Address: 118 Congress St

2014-00464

CHECK-LIST AGAINST ZONING ORDINANCE

Proposed Use/Work - new four story building - two commercial units 1st floor - 12 residential

BUILDING ELEVATIONS
A2.01

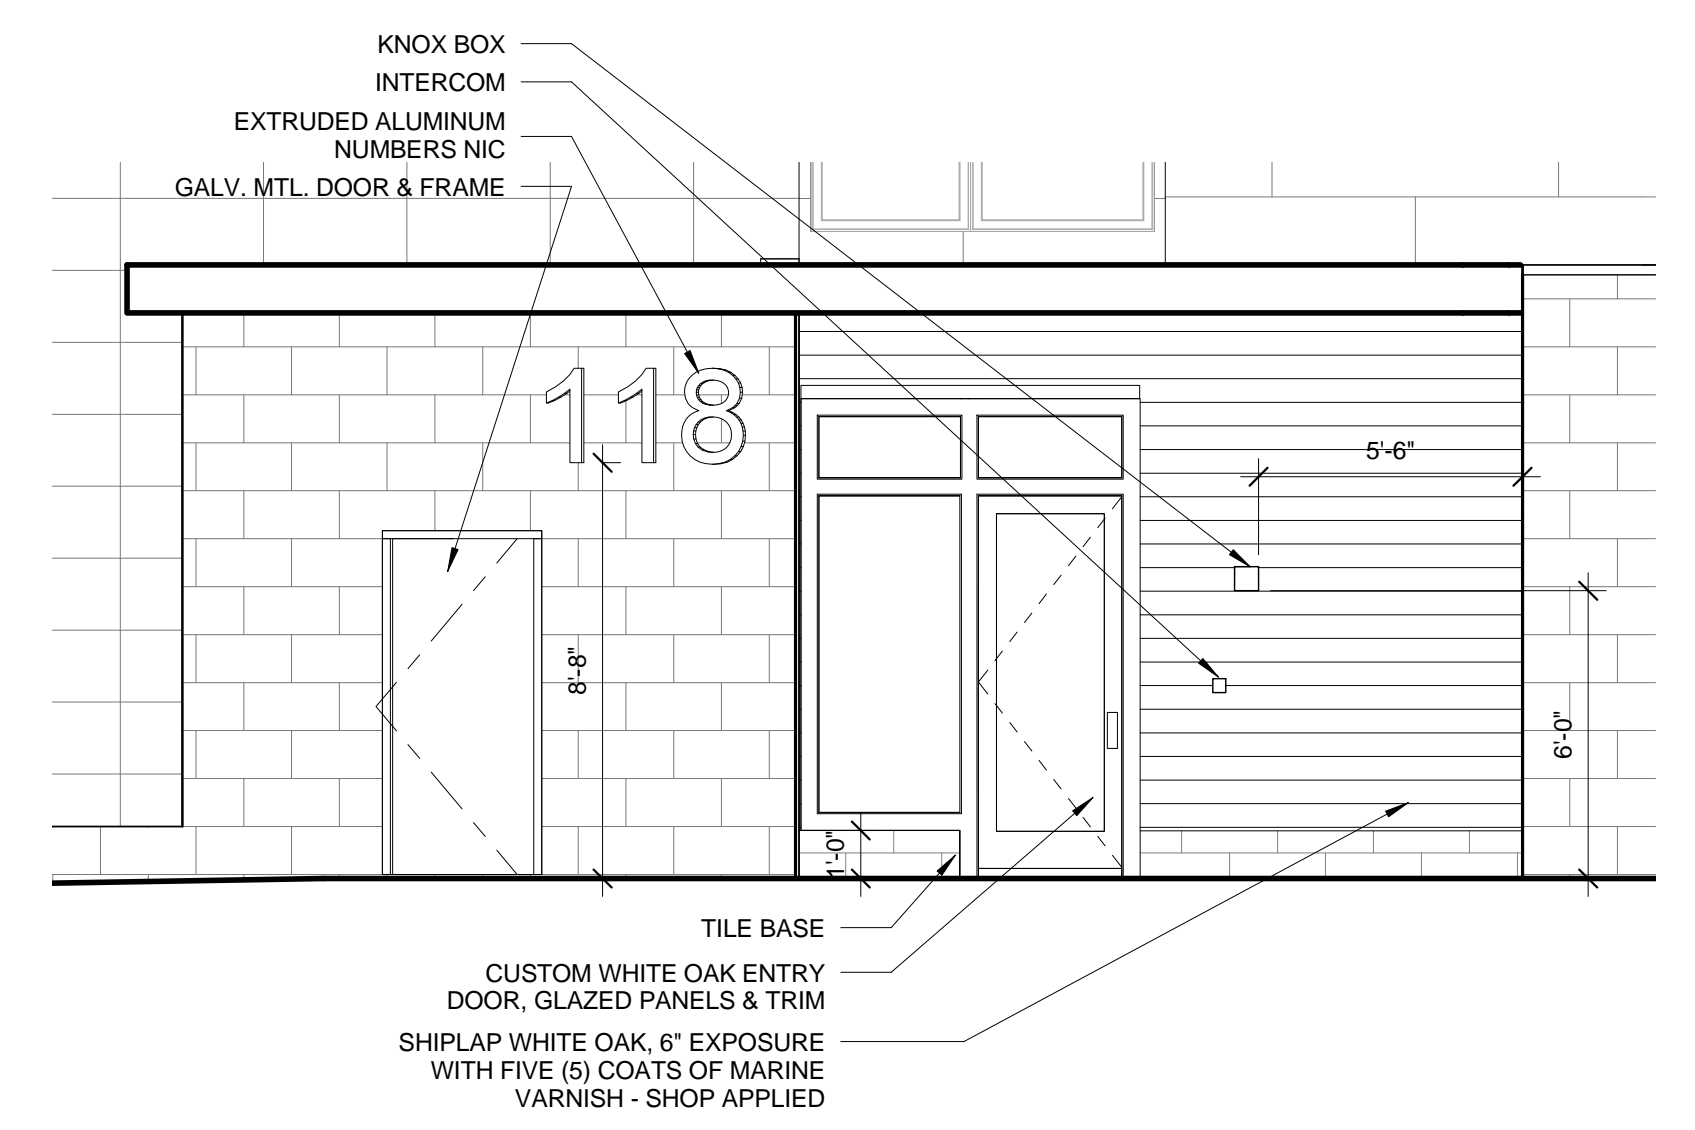
Front Yard - maximum - 10' or average - 1.5 given OK
overhangs will need city license

Height - 50' max (commercial 1st floor) 50' shown w/ average grade - 146.71'
